Application for Planning Permission for Works or Extension to a Dwelling

Development: Erection of single storey rear extension with associated internal alterations
Location: Little Haven Thorndene Avenue Bognor Regis PO21 2TP

I regret that I am unable to accept your documents as a valid application until the following item(s) have been received or resolved :-

PROPOSED GROUND FLOOR & SITE PLANS

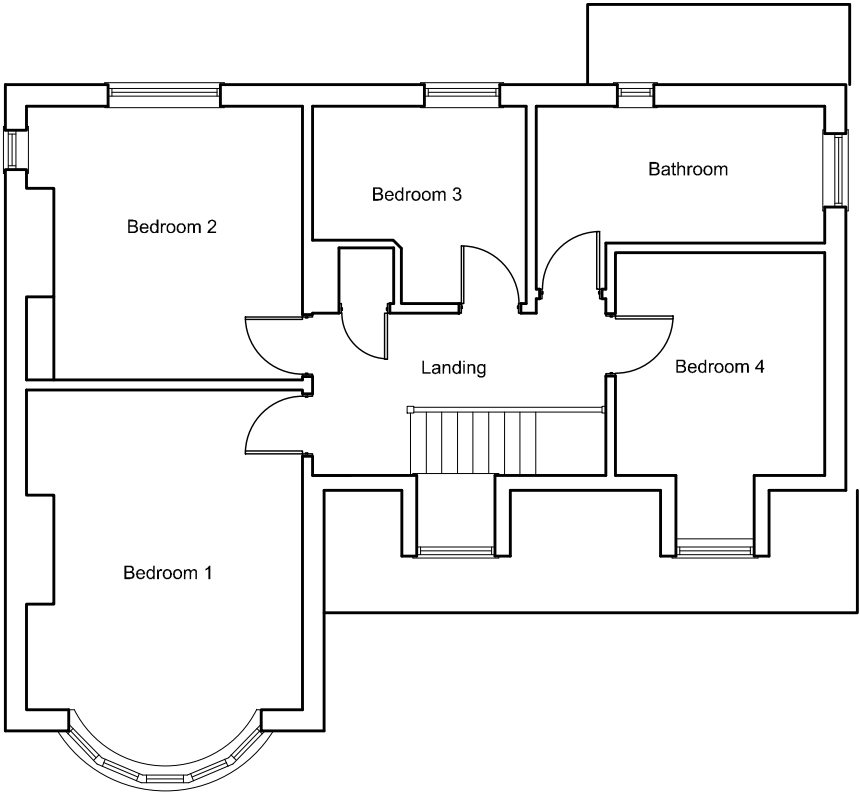
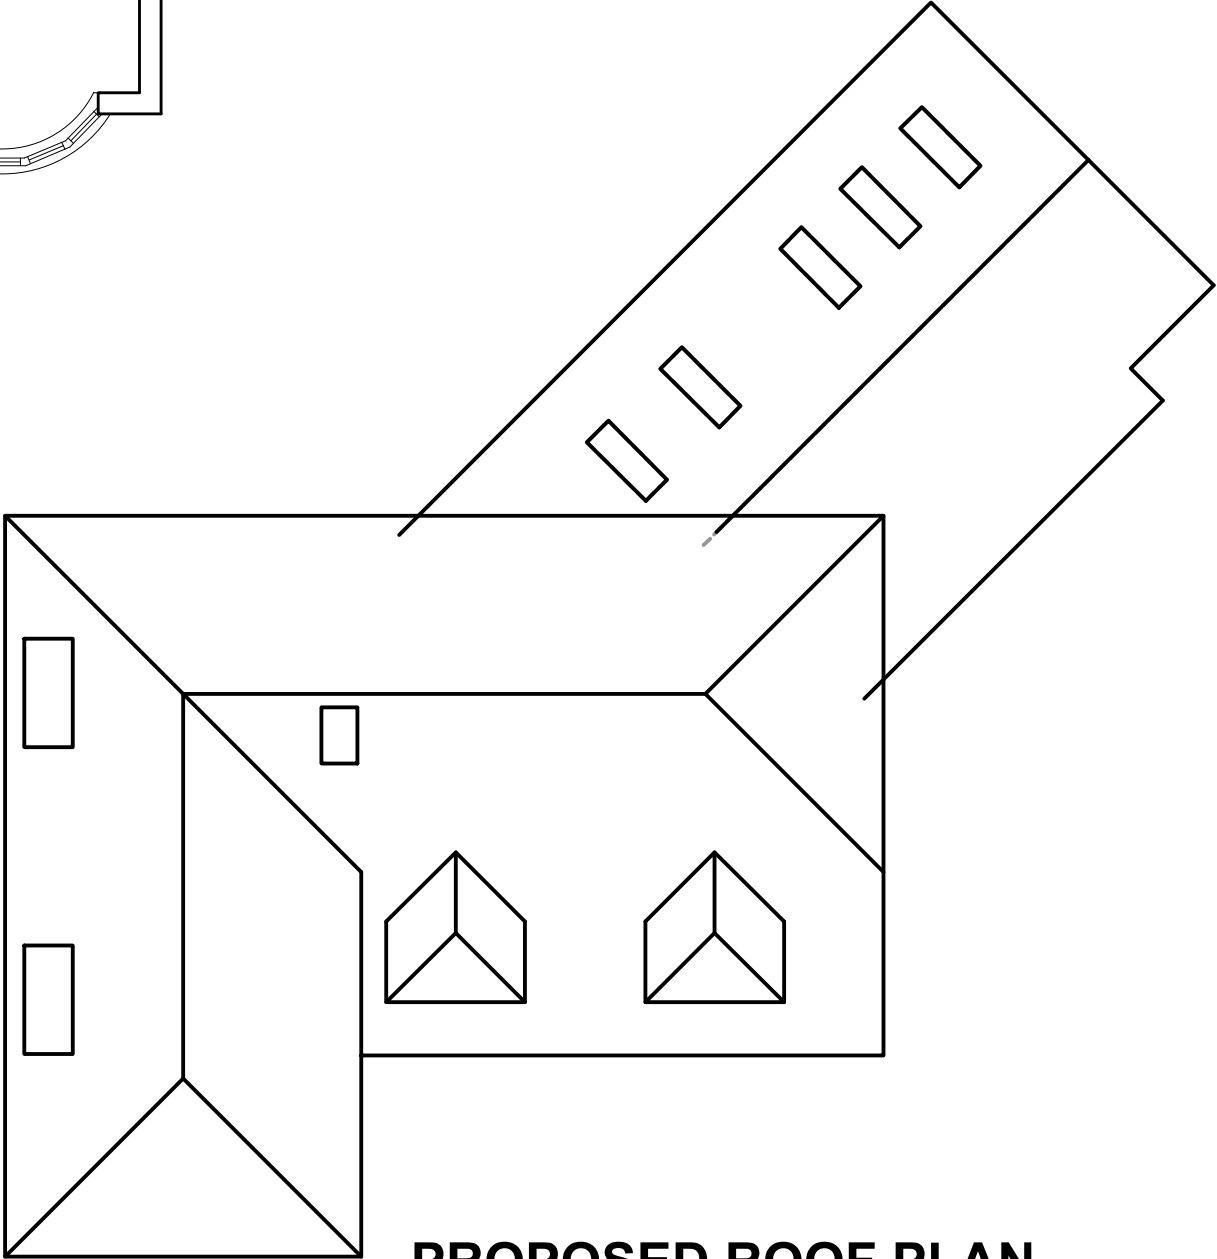
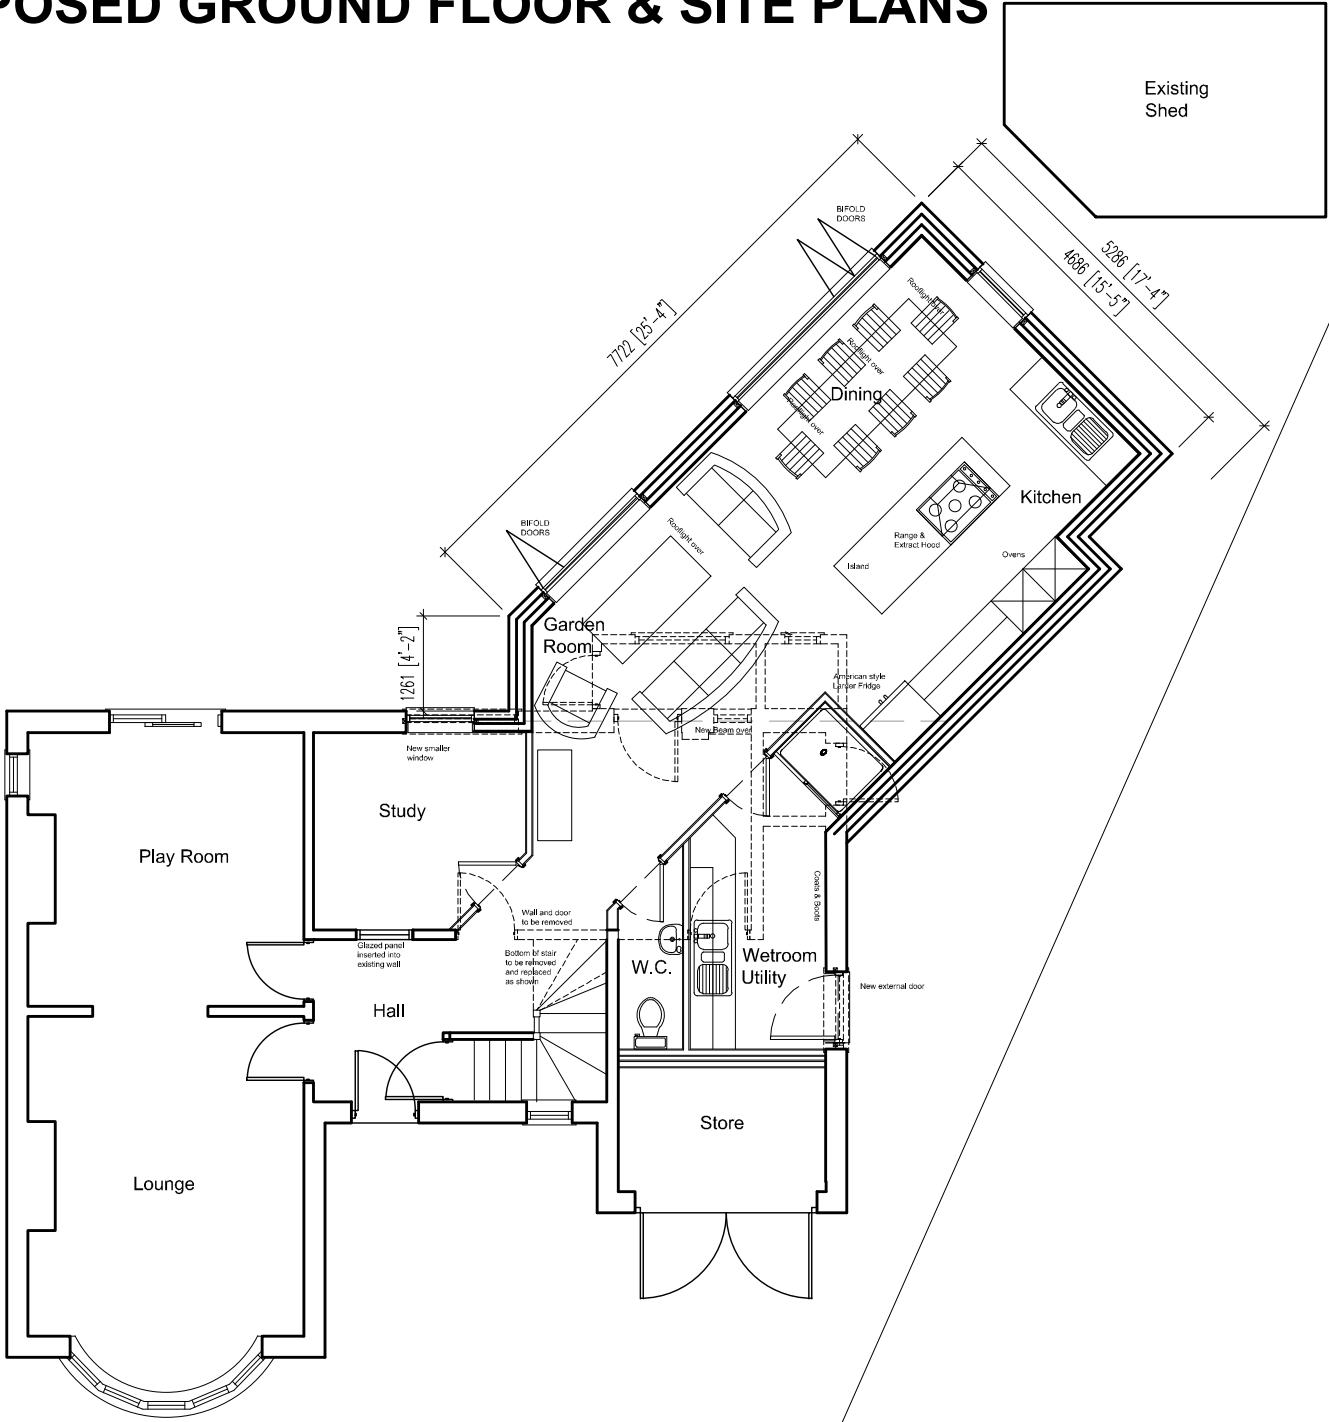
The window on the proposed north-east elevation is shown as a door on the proposed ground floor. Please review and amend accordingly.

BLOCK PLAN

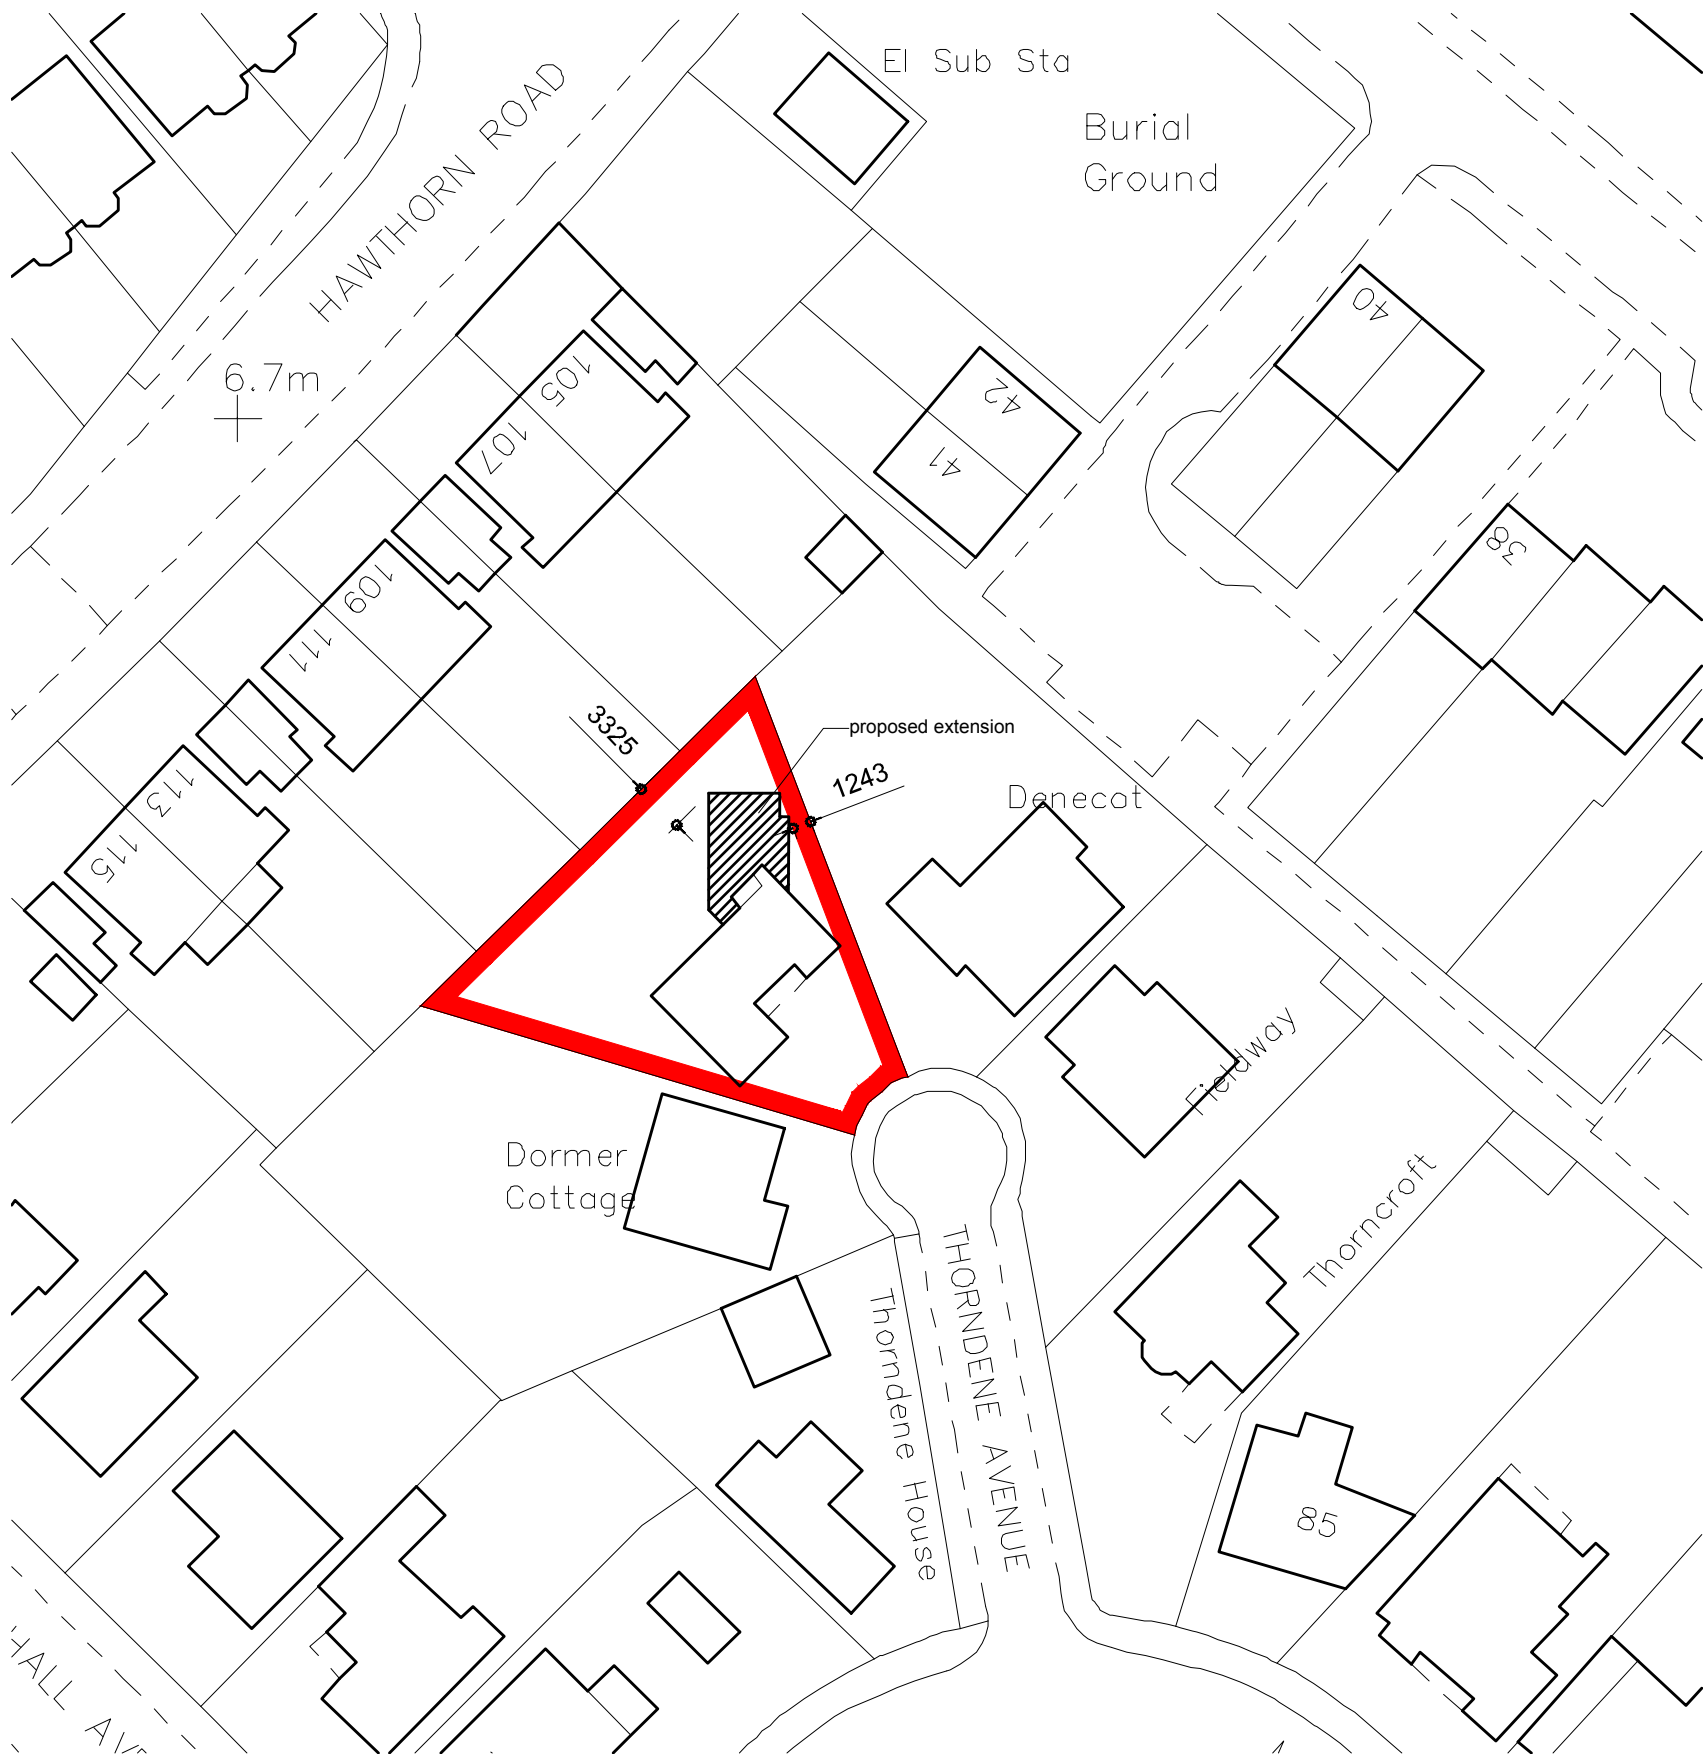
Block Plan

You are required to have dimensions from the proposed extension(s) to all site boundaries. Please amend
Plans
